Application by National Highways for A46 Newark Bypass

The Examining Authority's written questions and requests for information (ExQ1)

Issued on 15 October 2024

Drawing file: TR010065 / TR010065-000155-TR010065_A46 Newark Bypass_6.2 Figure 2.3 Environmental Masterplan.pdf

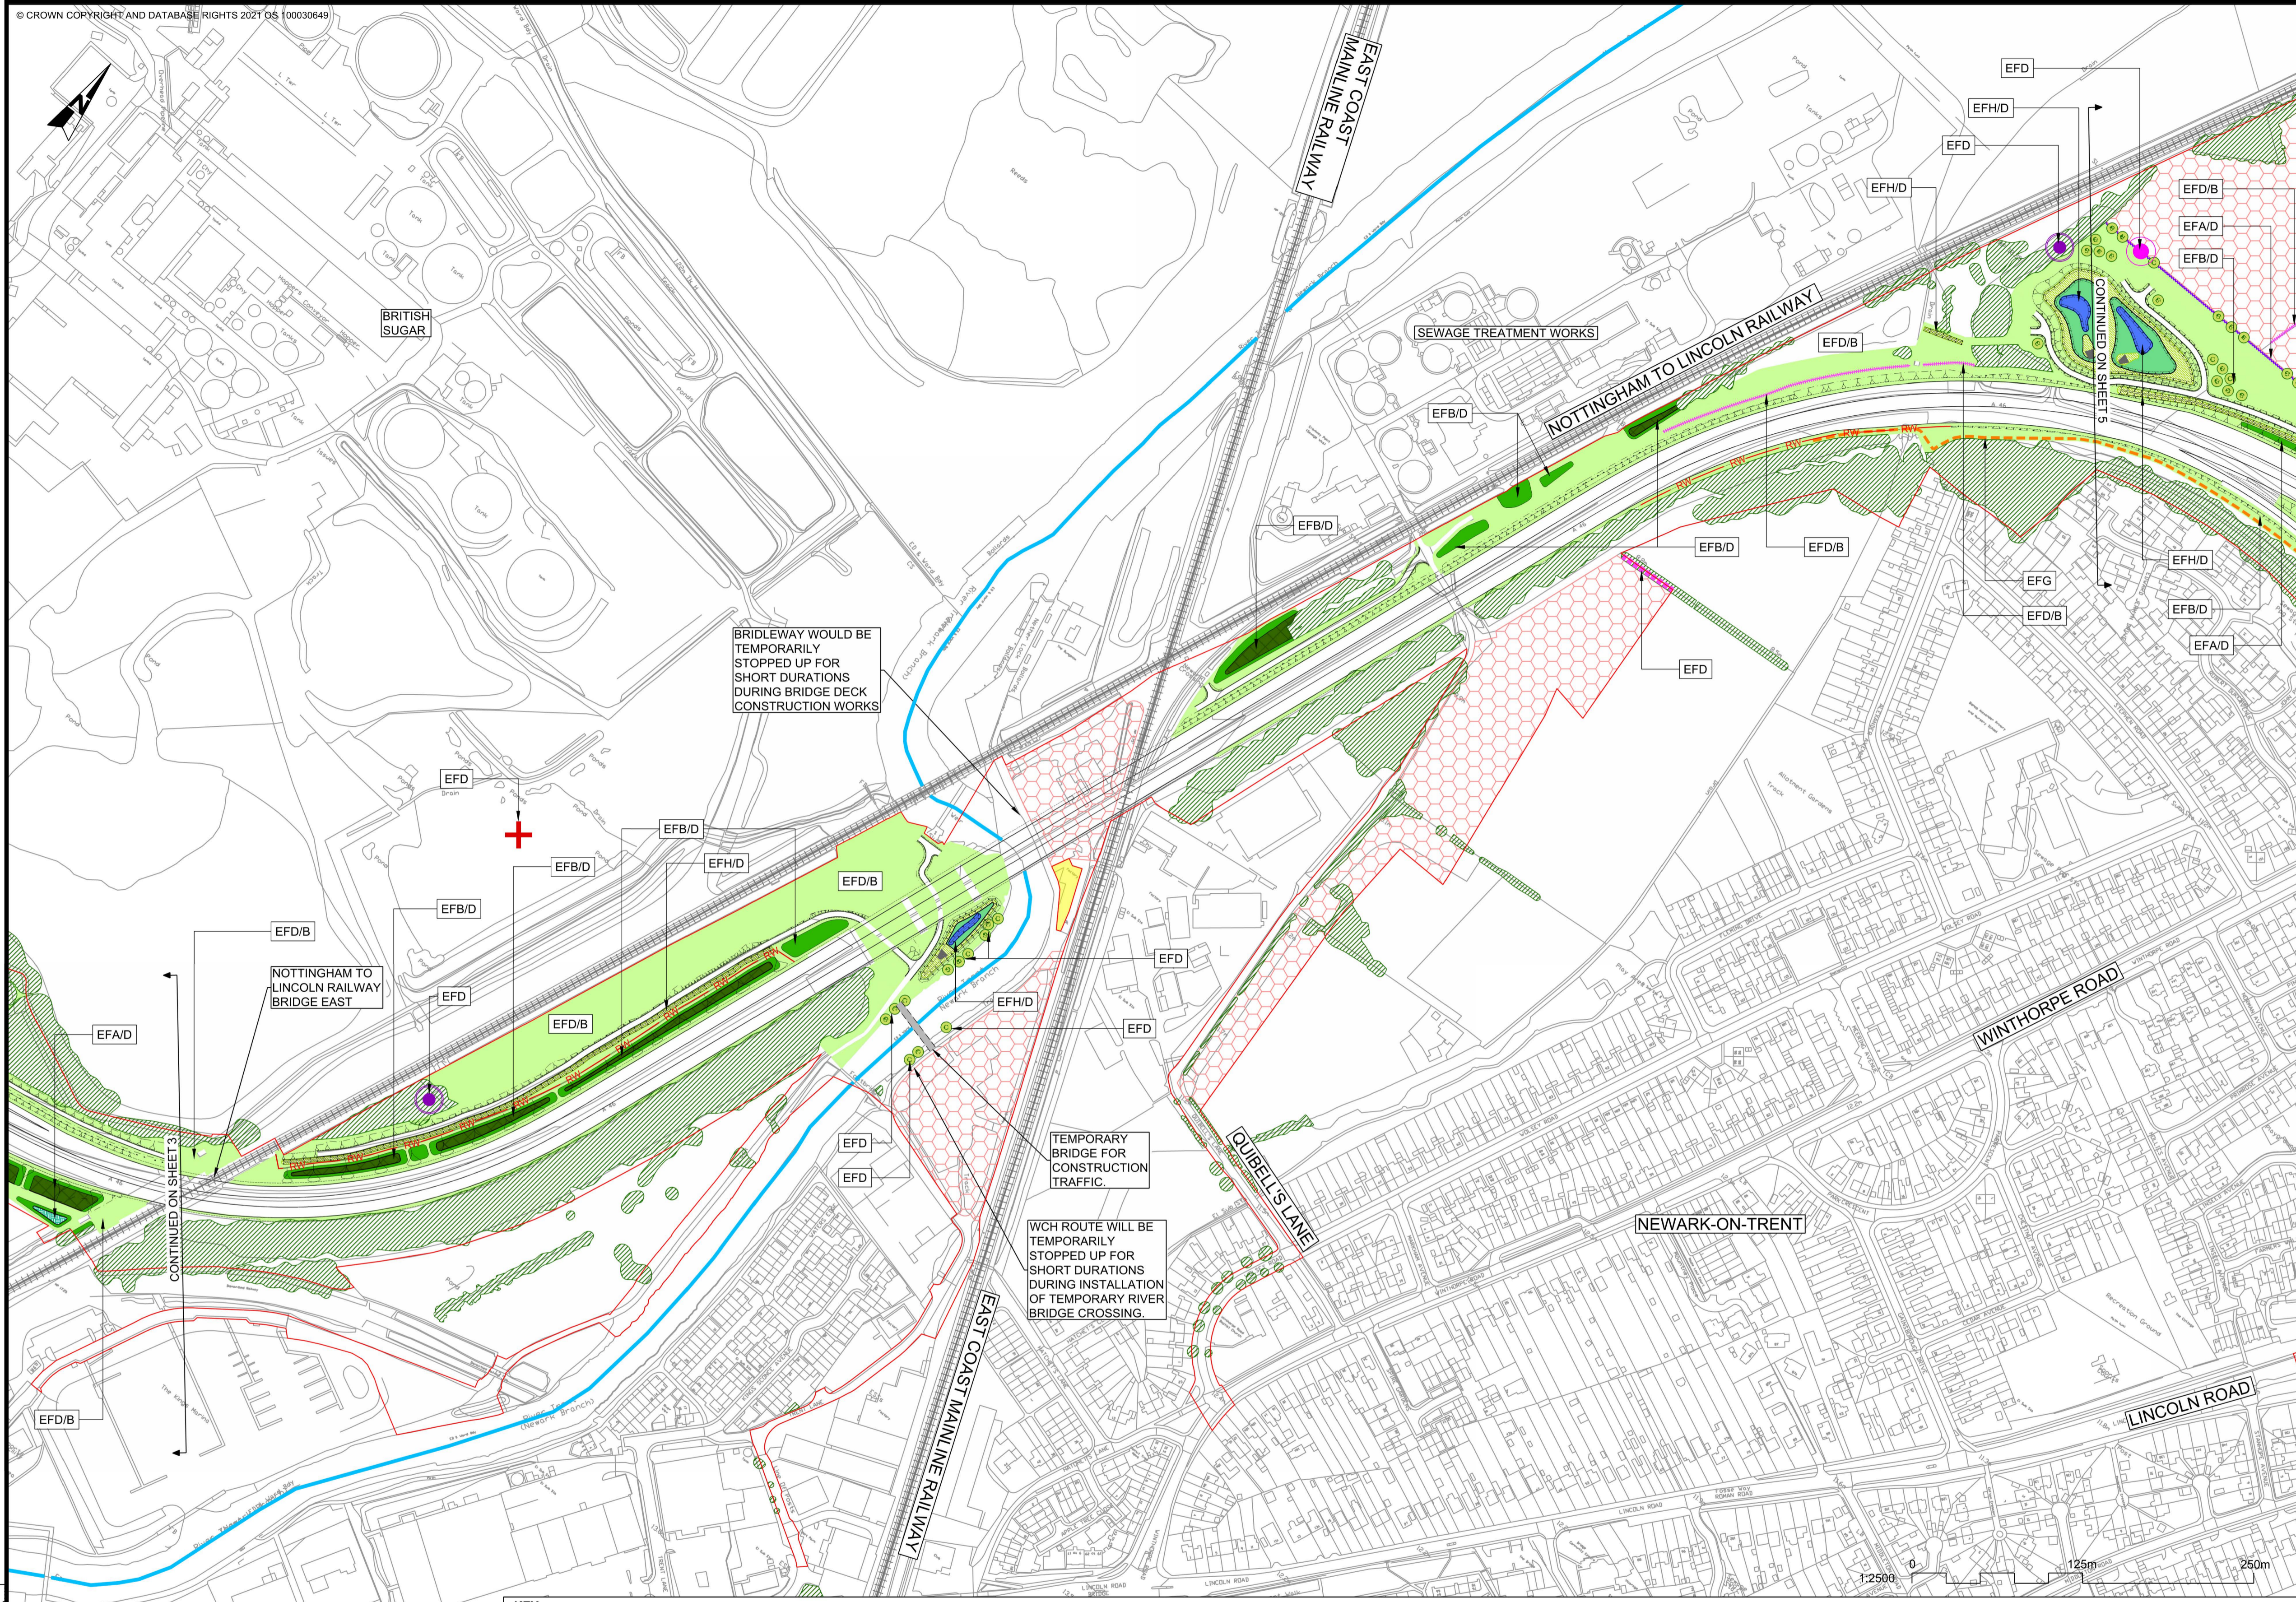
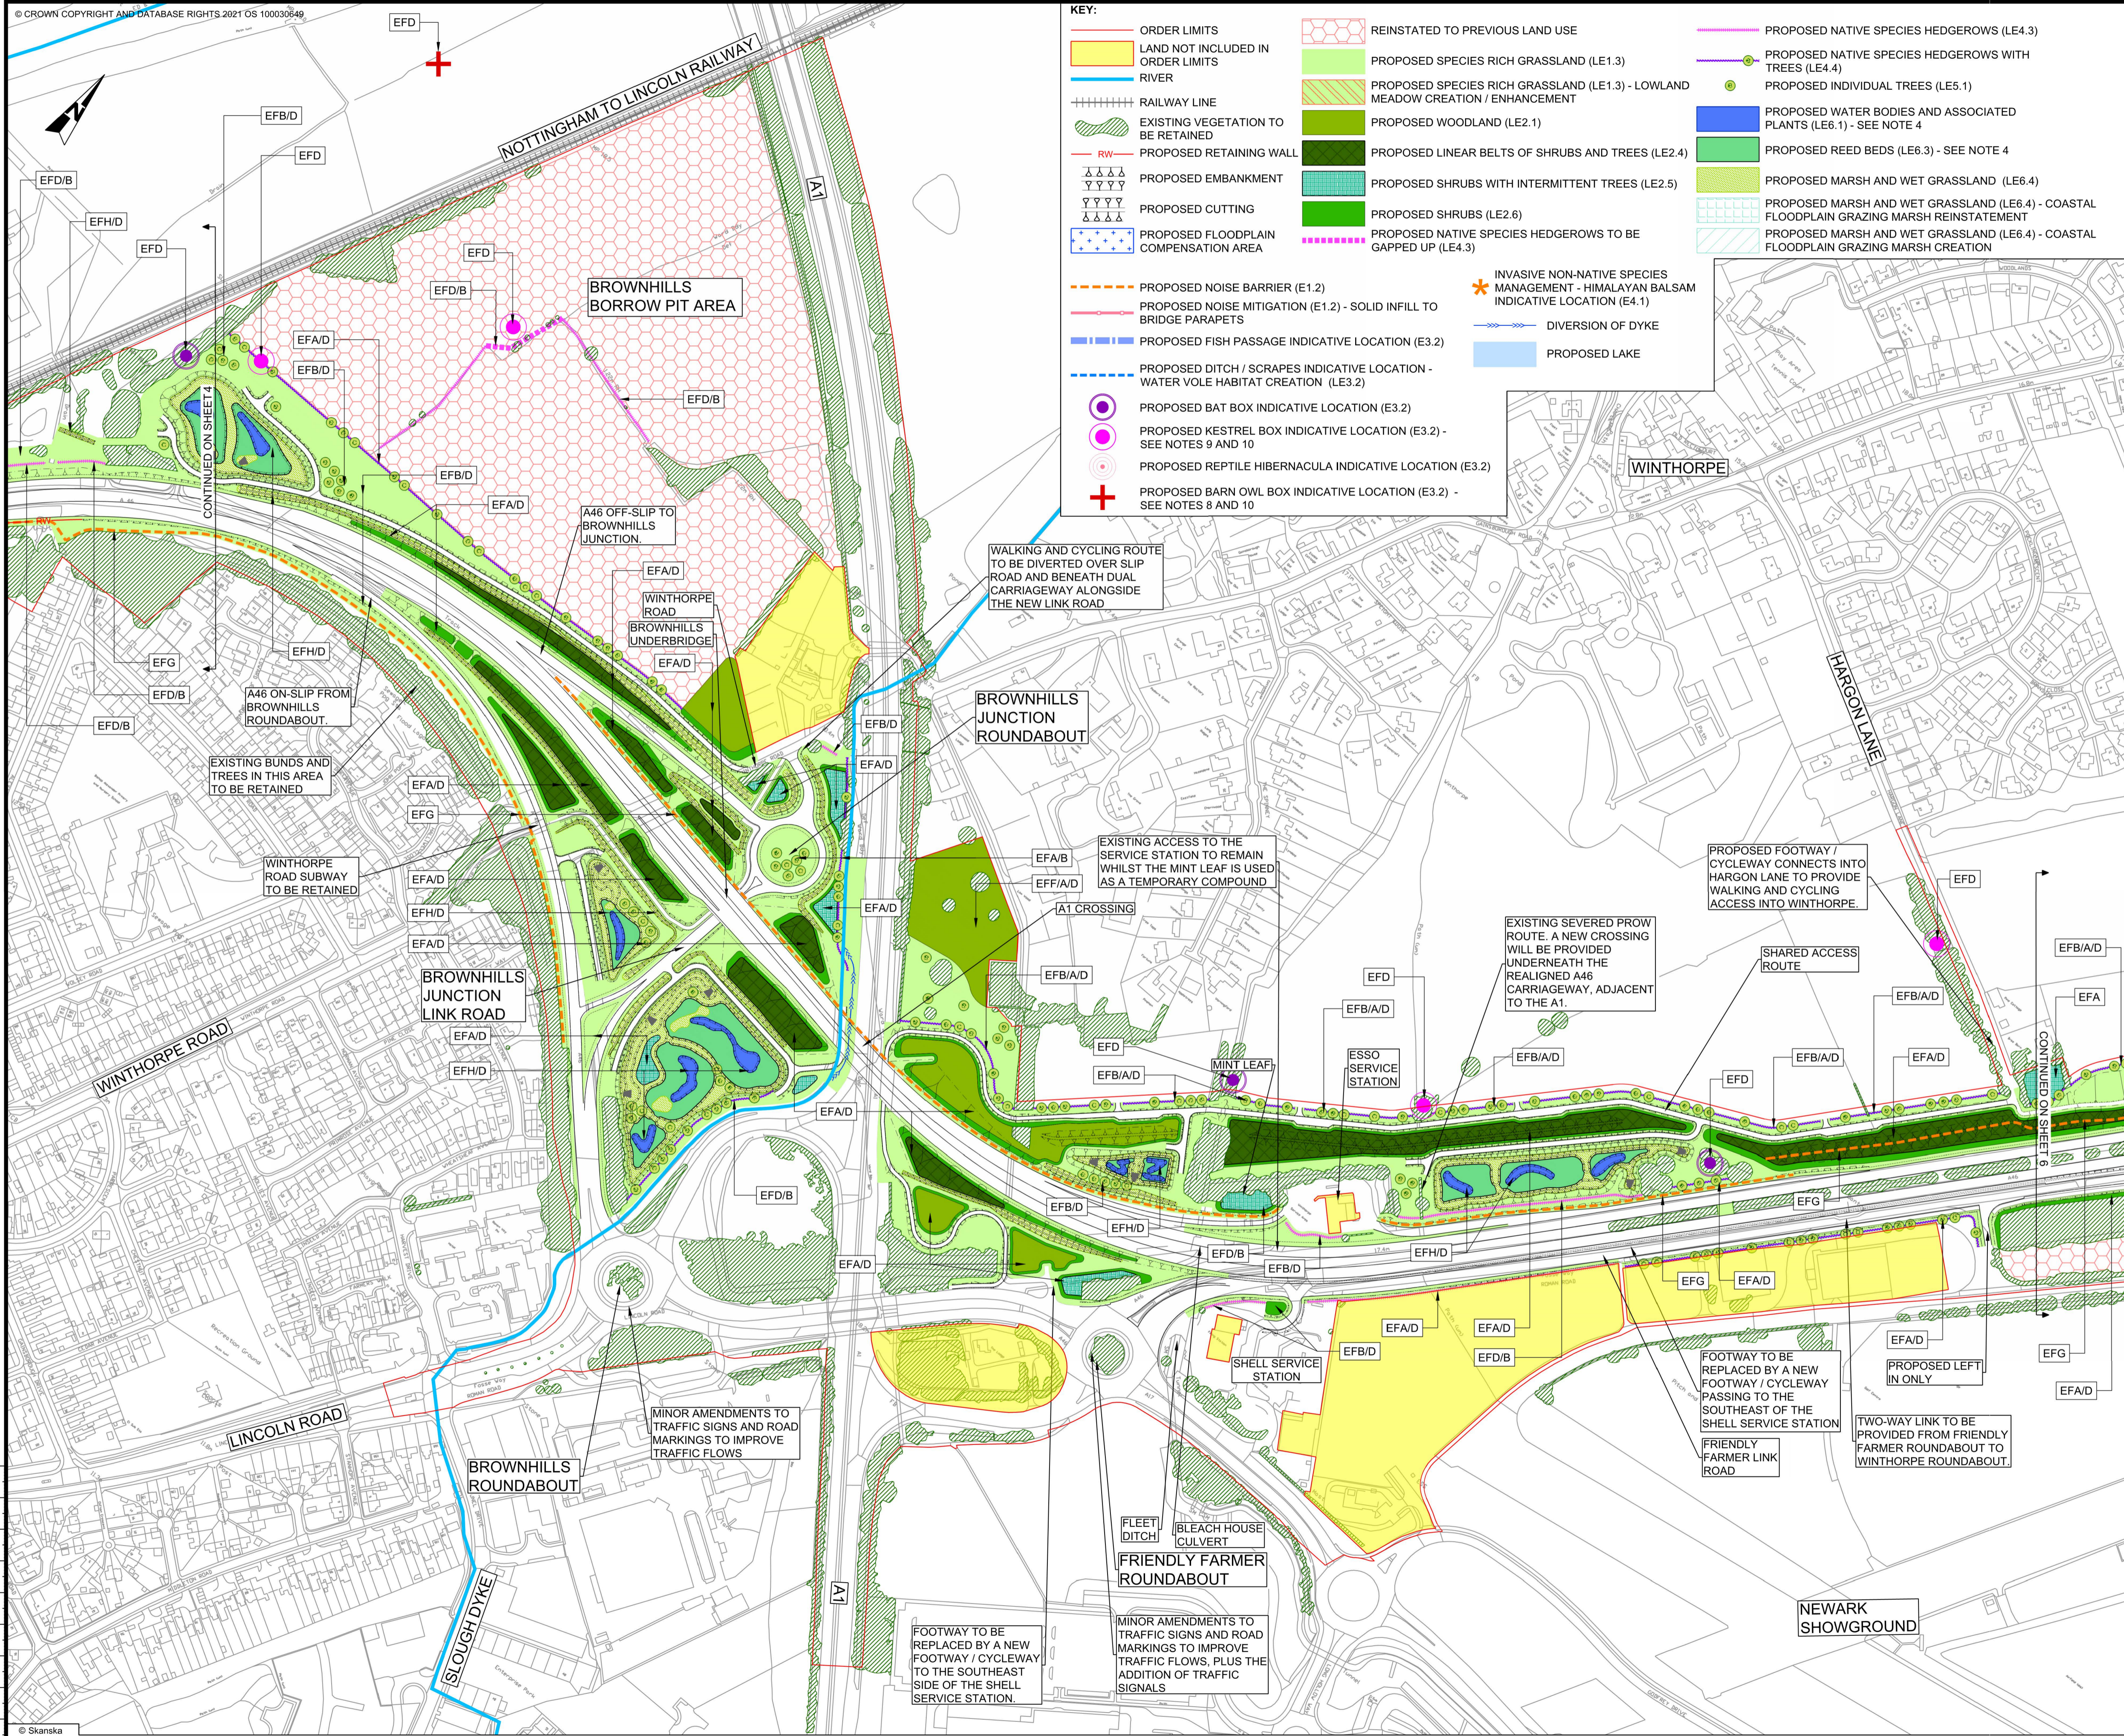
ExQ1	Question to:	Question:
		Figure 2.3 Environmental Masterplan [AS-026] shows compensation measures for barn owl boxes, kestrel boxes and bat boxes and areas of retained vegetation outside the Order limits. How will these be secured in the dDCO and who will be responsible for their maintenance.
Q3.0.4	The Applicant, NSDC	Habitat Severance ES Chapter 8: Biodiversity [APP-052] sets out the impact on habitats through paragraphs 8.11.8 to 8.11.12. This concludes a Slight Adverse effect during construction. With specific reference to the Environmental Masterplan [AS-026] please provide further explanation and justification of this conclusion and when doing so consider how the habitats currently link together creating green corridors and the impact of the Proposed Development to intrude on these networks resulting in habitat severance. Please also provide further detail on what opportunities have been identified to resolve existing issues of severance and those caused by the Proposed Development. Does the Council agree with this conclusion and if not, why not?
